TRANSMITTAL SHEET

<p>To: City of Mercer Island</p> <hr/> <p>Company: Department Services – Building & Planning</p> <hr/> <p>Address: 9611 SE 36 Street Mercer Island, WA 98040</p> <hr/>	<p>From: Erik Voris</p> <hr/> <p>Project: Project 2109-226</p> <hr/> <p>Date: 2/28/2022</p> <hr/> <p>Regarding: Correction Cycle#1</p> <hr/>
--	--

Planning Review Corrections received on 12/22/21 from Tim McHarg

1 ROOF PLAN
 A2.3 SCALE: 1/4" = 1'-0"

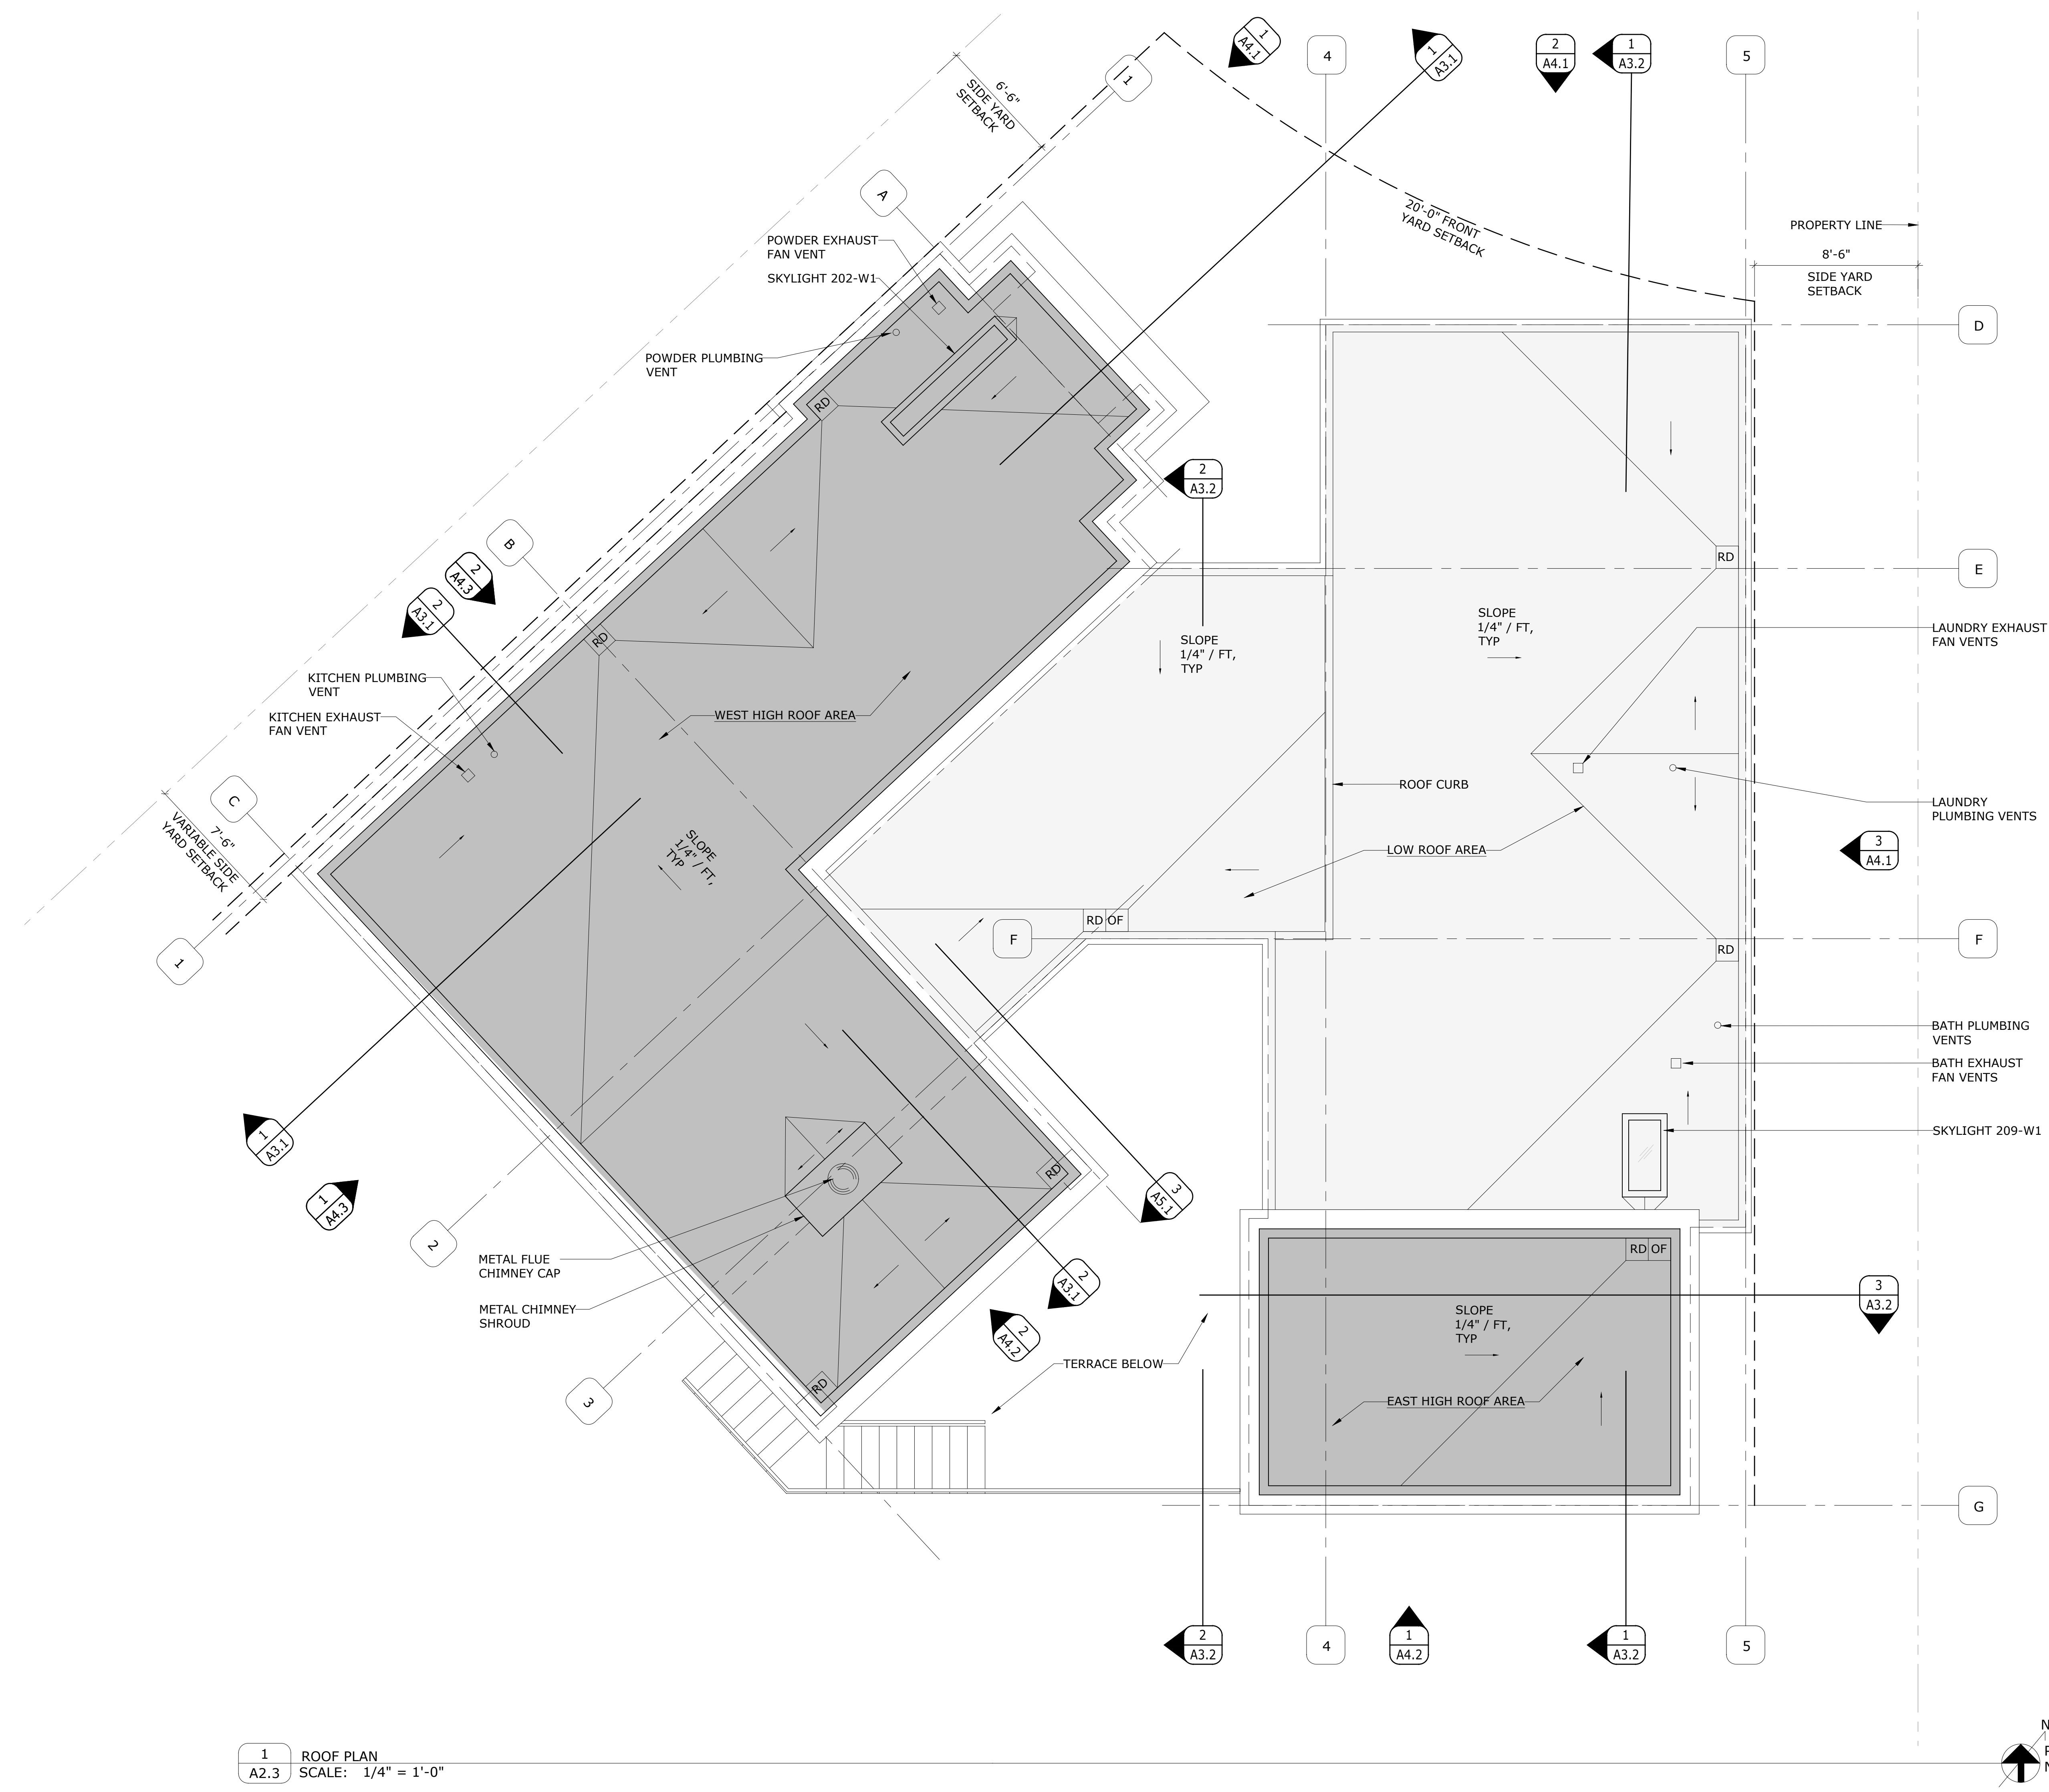
12. Cut a detail between the high and low roof areas on Sheet A2.3 to show relationship.
13. Detail 3/A5.1 is cut on the Roof Plan, Sheet A2.3. This detail does not exist.

14. Revise General Note 1, Sheet A2.3, as roof venting at 1:150 is required even with the vapor barrier. IRC R806.2, Exception 1, does not apply in Climate Zone 4C.

15. A vapor barrier is noted only at the low roof and west high roof areas according to General Note 2, Sheet A2.3. What about the east high roof?
16. Enclosed attics and rafter spaces must have cross ventilation for each space per IRC R806.1. The minimum net free ventilating area of 1:150 must be provided unless the provisions of the exception to IRC R806.2 are met which would not be applicable for this roof system. Address the following regarding the calculations provided on Sheet A2.3:

- a. The calculations for the west and low roofs use a required minimum net free ventilating area of 1:300. 1:150 must be used. Revise as necessary.
 - b. It appears that there are four 1-1/2" diameter holes for each 18" long block at the parapet caps. We calculate the net area provided to be 3.53 square inches per lineal foot assuming a 75% net free ventilation area. Your calculations assume 5.28 square inches per lineal foot is provided. Please explain/justify.

- c. The calculations assume the low roof area has 182.72' of vented parapet cap. Justify this perimeter. We assume Detail 3/A7.1 would apply at this condition which only vents the upper roof where the upper and lower roofs meet.

- 12 - The wall section 3/A5.4 and structural details 7 & 12/S4.2 show the condition between the high and low roof areas.**
- 13 - The wall section marker 3/A5.1 on sheet A2.3 has been revised to 3/A5.4.**

- 14 - The high and low roof assemblies have been revised to a non-vented roof / attic assembly per R806.5 - 5.1.3 & 5.1.4. See the revised Typical Low Slope Roof Assembly on wall section 1/A5.1.**

- 17 - The roof plan drainage was revised to thru-wall scuppers with conductor heads and downspouts on the outside of the building, with the exception of the roof drains to remain over the covered patio roof. Each roof area has multiple drains or thru-wall scuppers to meet the requirements for secondary drainage. See revised A2.3.**

A4.3

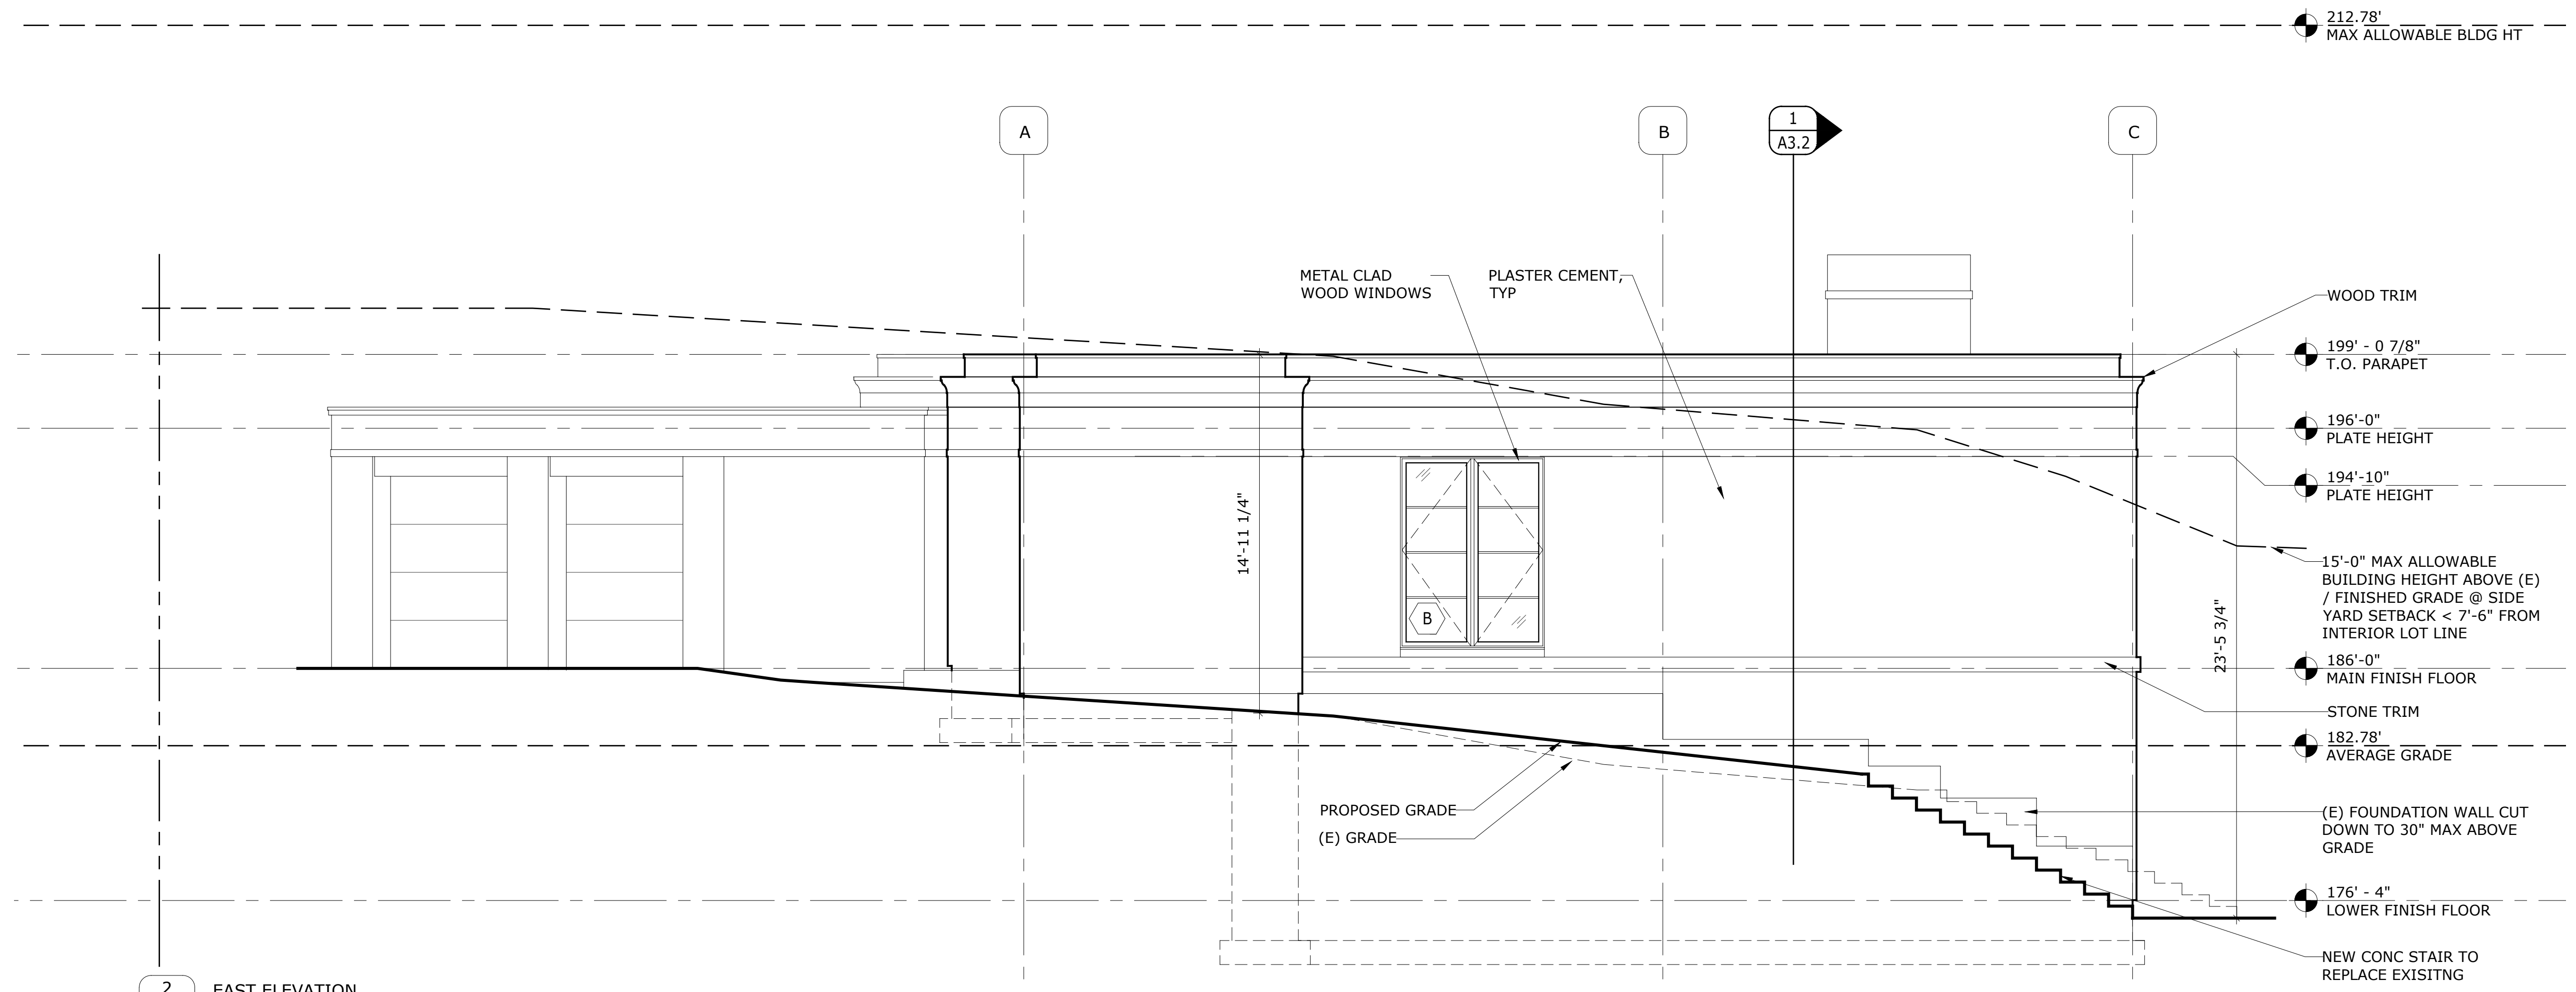
1. Lot slope is 16.3%. Please correct for clarity.
2. Please confirm that existing rockeries have been included in the "retaining wall" line item in the hardscape calculations. If not, please add them as a separate line item.
3. Please provide Average Building Elevations on this sheet or on Sheet A1.1.
4. Please clarify surfacing after pool/patio demo to confirm it is not hardscape.
5. Please provide seating wall height. Per 19.02.020.C.3.g, all portions of the seating wall in the rear yard setback must be 30" or less.
6. Per MICC 19.02.020.C.3.a.ii, no building elements are permitted to encroach into minimum side yard setbacks. Since this is part of the foundation, it is a building element. The existing foundation wall will need to be cut down to match proposed grade.
7. Please correct to West Elevation.

- 7 - The title of the elevation on 2/A4.3 has been revised to read West Elevation.**
